**BERNALILLO COUNTY RECOVERY SUPPORT CENTER**  
**Traffic Circulation Layout (TCL) Letter of Response**

A1 TRAFFIC CIRCULATION LAYOUT

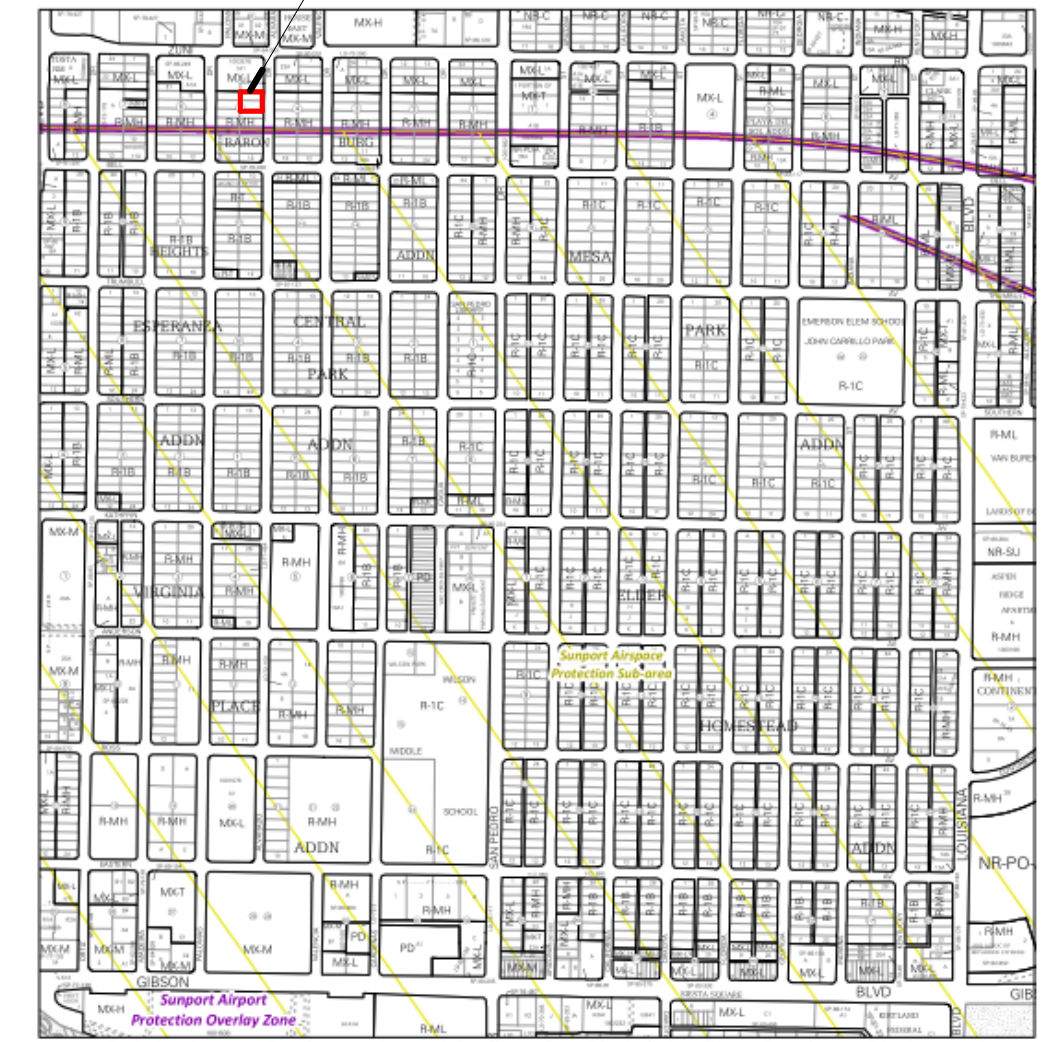
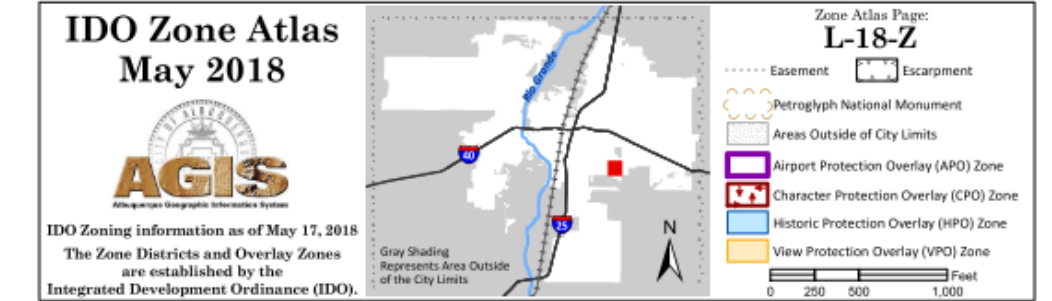
2. Identify all existing access easements and rights of way width dimensions.
  - a. *See updated TCL drawing*
3. Identify the right of way width, medians, curb cuts, and street widths on Cardenas Dr.

- a. *See updated TCL drawing*
4. Provide shared parking agreement and shared access agreement.
  - a. *See signed forms attached*
5. Show on the site plan the location and the dimensions of the 15 parking spaces on the adjacent property.

- a. *See updated TCL drawing with calculations for both sites*
7. The ADA accessible parking sign must have the required language per 66-7-352.4C NMSA 1978 **"Violators Are Subject to a Fine and/or Towing."** Please call out detail and location of signs.

- a. *See updated TCL drawing with Signage Detail*
8. The ADA access aisles shall have the words **"NO PARKING"** in capital letters, each of which shall be at least one foot high and at least two inches wide, placed at the rear of the parking space so as to be close to where an adjacent vehicle's rear tire would be placed. (66-1-4.1.B NMSA 1978)

10. Motorcycle parking spaces shall be designated by its own conspicuously posted upright sign, either free-standing or wall mounted per the zoning code.

- a. *See updated TCL drawing with Signage Detail*
11. The pavement marking "MC" should be shown in the opposite direction for motorcycles entering the parking space.

12. All bicycle racks shall be designed according to the following guidelines:
  - a. The rack shall be a minimum 30 inches tall and 18 inches wide.
  - b. The bicycle frame shall be supported horizontally at two or more places. Comb/toaster racks are not allowed.

14. A 1-foot clear zone around the bicycle parking stall shall be provided.
  - a. *See updated TCL drawing with Bicycle Rack Details*
15. Bicycle parking spaces shall be at least 6 feet long and 2 feet wide.

17. Provide a copy of Fire Marshall Approval.
  - a. *See Approved Fire 1 Plan*
18. All one-way drives shall have “One Way” and “Do Not Enter” signage and pavement markings. Please show detail and location of posted signs and striping.

- a. *See updated TCL drawing*
19. Show the clear sight triangle and add the following note to the plan: “Landscaping and signage will not interfere with clear sight requirements. Therefore, signs, walls, trees, and shrubbery between 3 and 8 feet tall (as measured from the gutter pan) will not be acceptable in the clear sight triangle.

- a. *See updated TCL drawing*
20. Add a note stating “All broken or cracked sidewalk must be replaced with sidewalk and curb & gutter.” A build note must be provided referring to the appropriate City Standard drawing.

- a. *See updated TCL drawing*
6. To obtain approval for the shared parking agreement, provide parking calculations for the adjacent property (EPC) which should have an adequate number of parking spaces.

- a. *See updated TCL drawing*
9. ADA curb ramps must be updated to current standards and have truncated domes installed.
  - a. *See updated TCL drawing and General Sheet notes referencing COA standards.*

- a. *See updated TCL drawing*

- a. *See updated TCL drawing with Bicycle Rack Details*
13. Bicycle racks shall be sturdy and anchored to a concrete pad.
  - a. *See updated TCL drawing with Bicycle Rack Details*

- a. *See updated TCL drawing with Bicycle Rack Details*
16. Refuse vehicle maneuvering shall be contained on-site. The refuse vehicle shall not back into the public right of way.; provide a copy of refuse approval.

- a. *See updated TCL drawing, General Notes*
